On the description / development it should be noted when it says demolition of existing conservatory and erection of single storey side extension (within a Conservation Area) the reason for the demolition is due to building the single storey illegally without planning permission in the first instance.

PROPOSED ROOF PLAN
1:100 @ A1

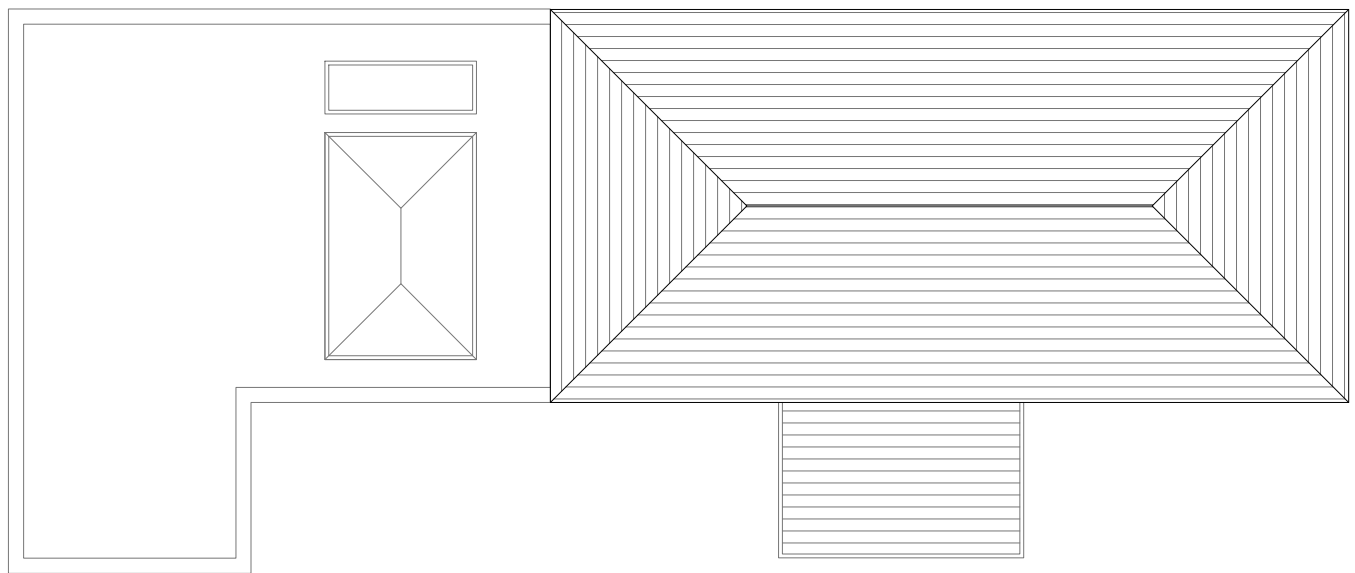
The flat roof proposed doesn't match the conservation area, also the design submitted relates poorly to the host and as such would be out of character with the traditional stylings of the main house.

PROPOSED FRONT ELEVATION
1:100 @ A1

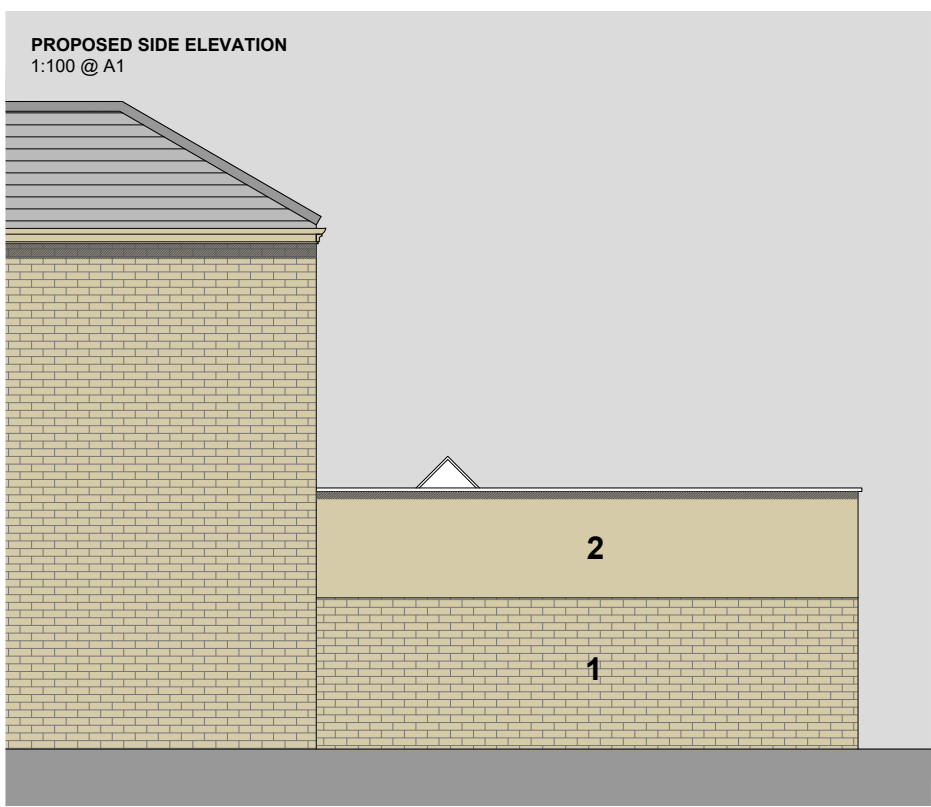
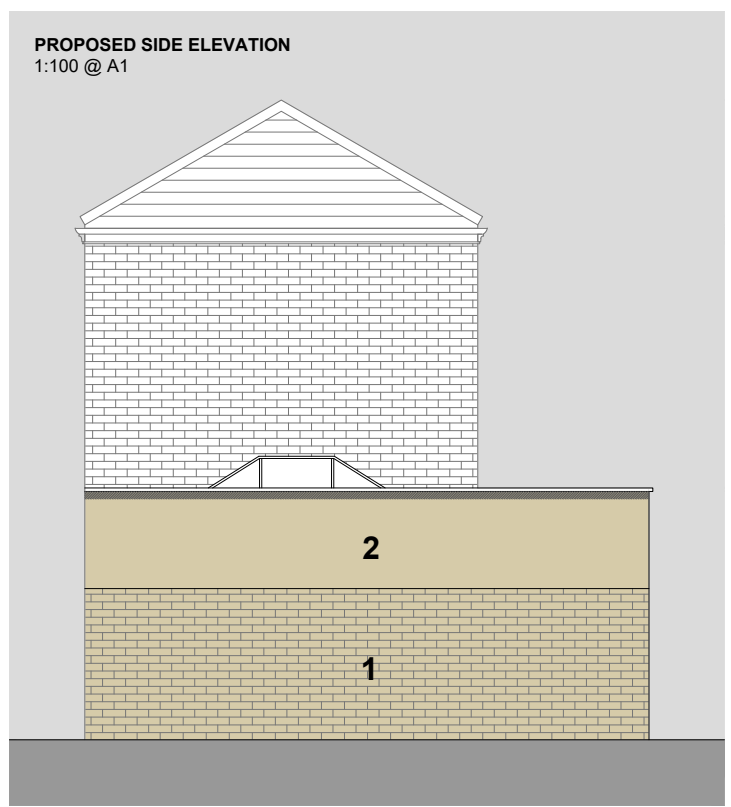
The rear elevation materials must match the current property, they should not be using rendering anywhere. In fact, all the materials/bricks on the front, side, rear should match the current property. Rendering mustn't be used at all as this will be inappropriate with a conservation area.

The proposed hight on the new application is too high, in whole will make the area look monstrosity.
